13 June, 2013

To Mr. Andrew Kottkamp
Hearings Examiner Kittitas County
Dear Mr. Kottkamp,

Please accept my comments on the CU-12-00002 Canyon River Ranch CUP application. While I strongly believe this project is exactly the type of attraction that can provide an excellent economic driver for Kittitas County, using the natural beauty the Yakima River provides, there are several flaws in the current application. Fortunately, these problems can easily be remedied by purchasing and retiring upstream senior water rights.

Canyon River Ranch II
Proposed Conditional Use Site Plan

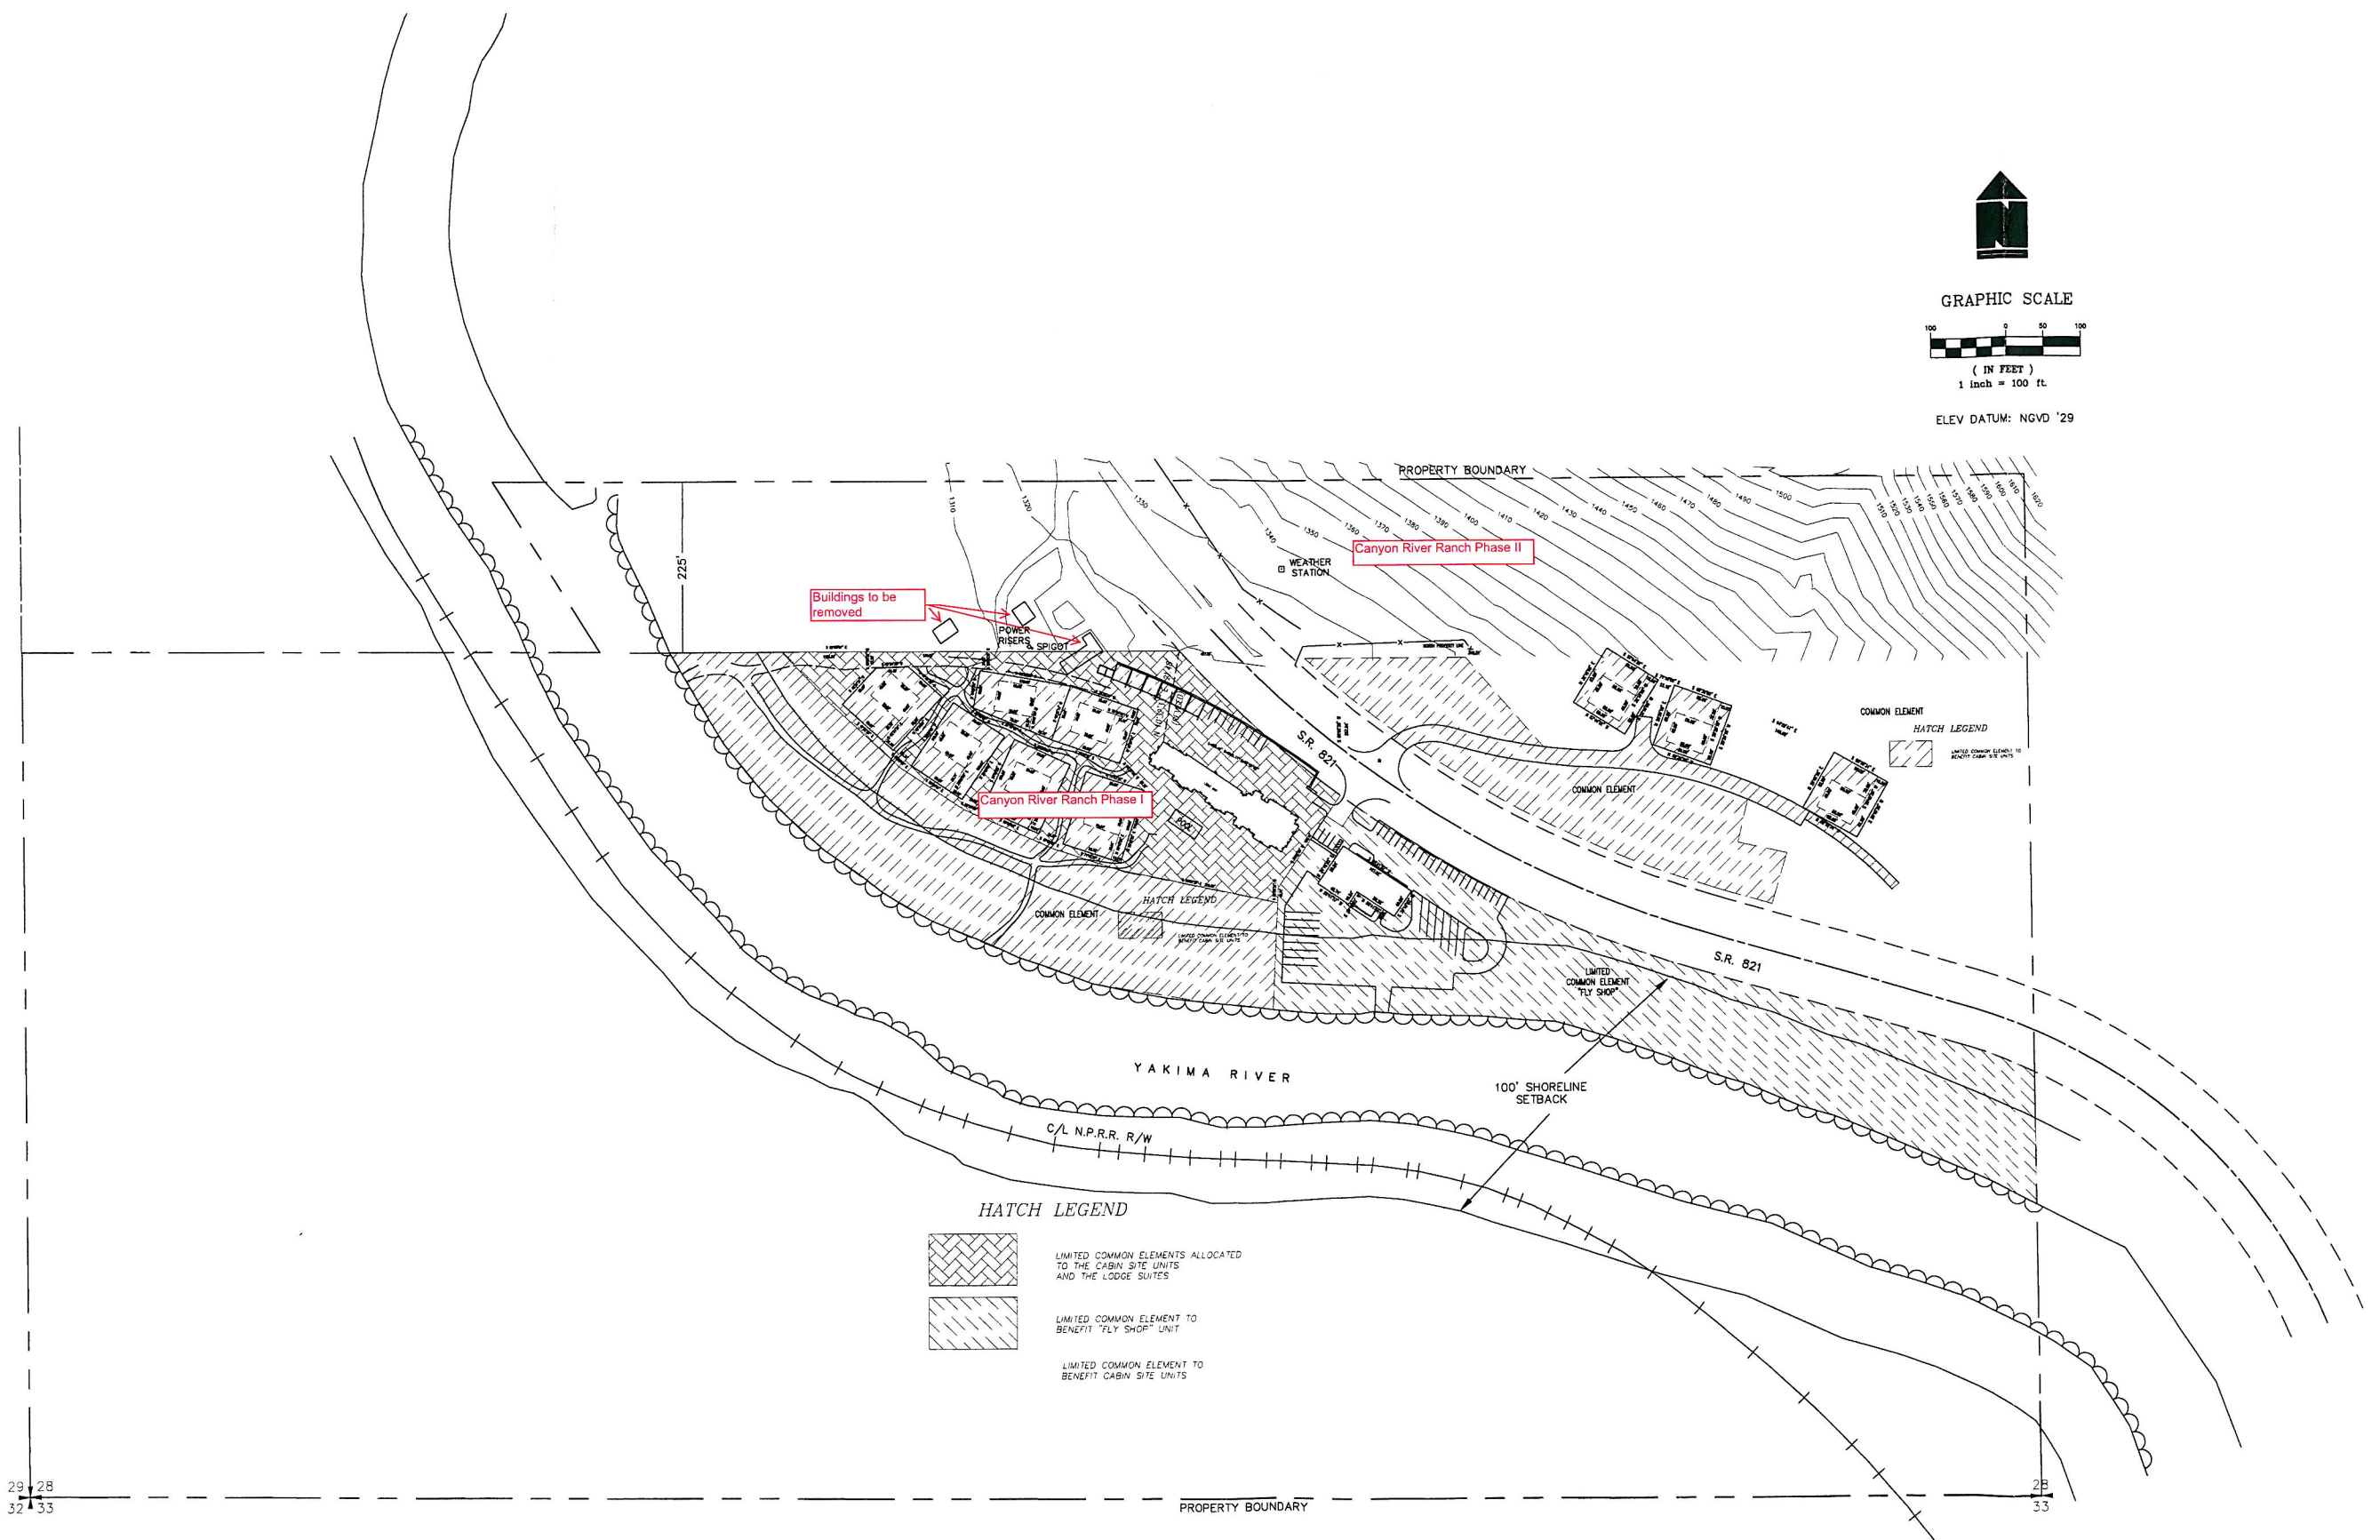
Regarding the Department of Health, I have included a link for the DOH Sentry Program Water System ID 72990. This has current information on the hook-ups allowed for this system. It shows they have recently been approved to increase the number of hook-ups from 14 to 18. However, the application clearly shows a total of 22 cabins plus the lodge and miscellaneous outbuildings. The math does not add up.

Based on the existing structures, I believe the current use must exceed the amount of water allowed under the permit-exempt well exception, especially with the vineyards that have been added and the grand lodge, both in terms of instantaneous and annual usage. It is important to remember that even if this permit-exempt well is within the 5,000 gal/day, their beneficial use includes the amount historically used - not an automatic 5,000 gal. Any expansion of an existing well is considered a new use by Ecology. However, I believe this is not presently a compliant well and the addition of more cabins will only exacerbate the problem. This well is a mere 32 feet deep (see the DOH Sentry program).
